Bernalillo County Regional Recreation Complex Mesa del Sol, draft TIS  
HT# R15D002  
received 4/18/2022

COA preliminary observations and comments 5/11/2022

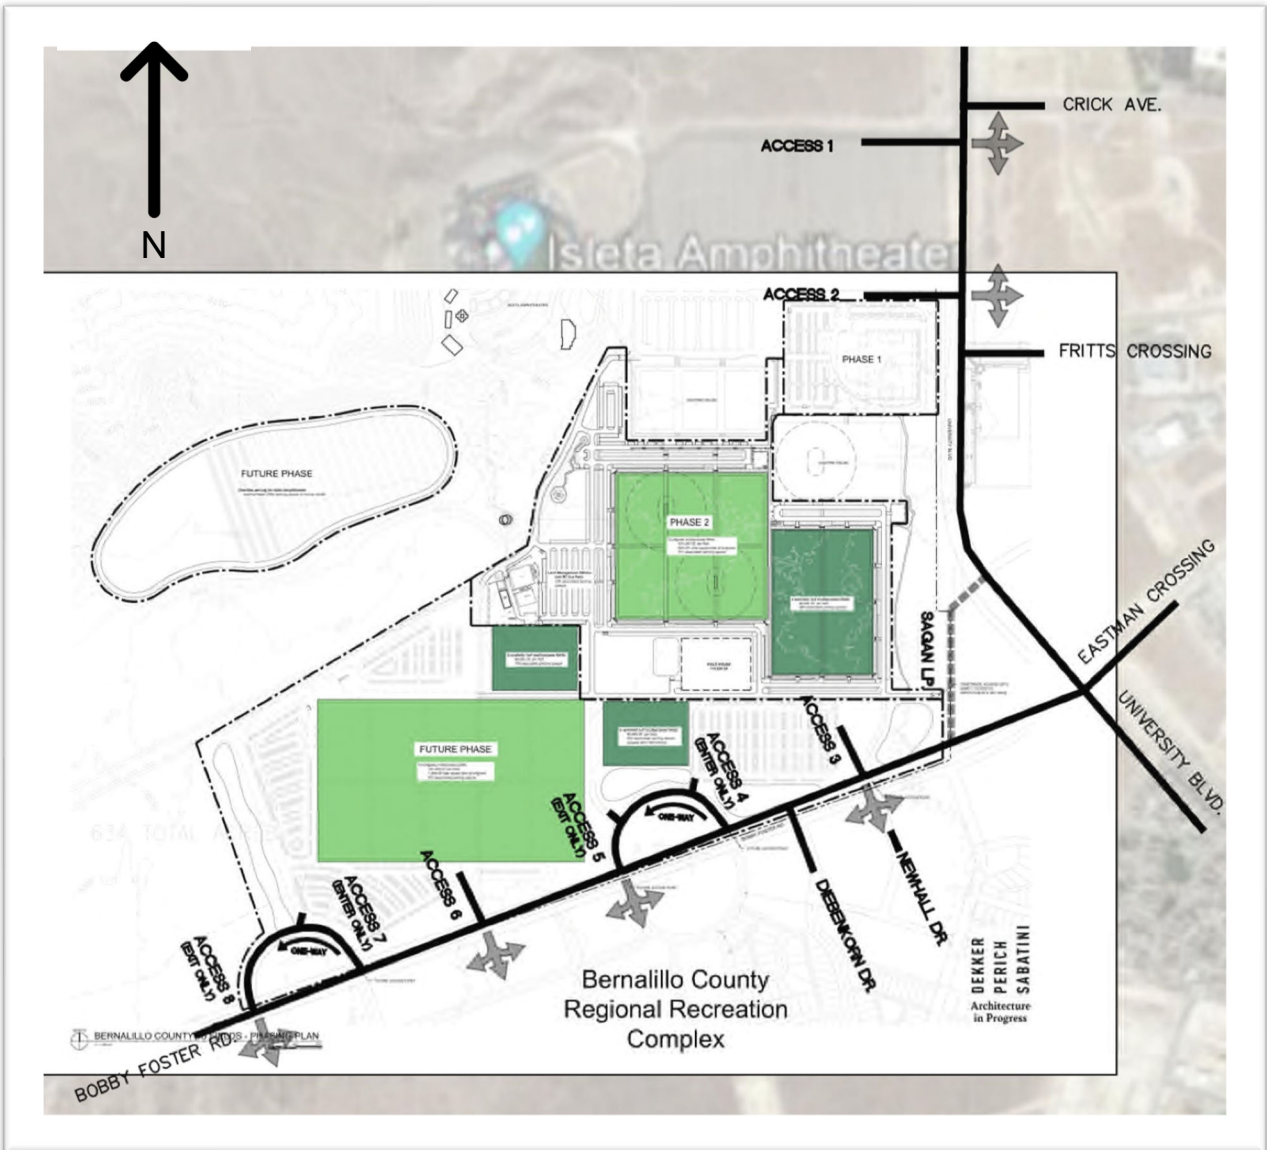
The mis-alignment of Fritts Crossing with the Access #2 should be addressed as the traffic not being associated. The two streets do not serve the same traffic, east of University is commercial large businesses and the west side is a recreation complex. The separation is approximately 300 feet and could function independently. This should be investigated in the report. ABQ Studios are vacating the streets connecting to Fritts crossing. This will restrict growth associated with Fritts Crossing. Additionally, access to Frits Crossing can be from Crick Ave. using Turning Drive and Watson drive.

Crick Ave. and Access #1 should be aligned. They are too close together to operate independently and the traffic volumes on Crick Ave. will be increasing due to development potential east of University.
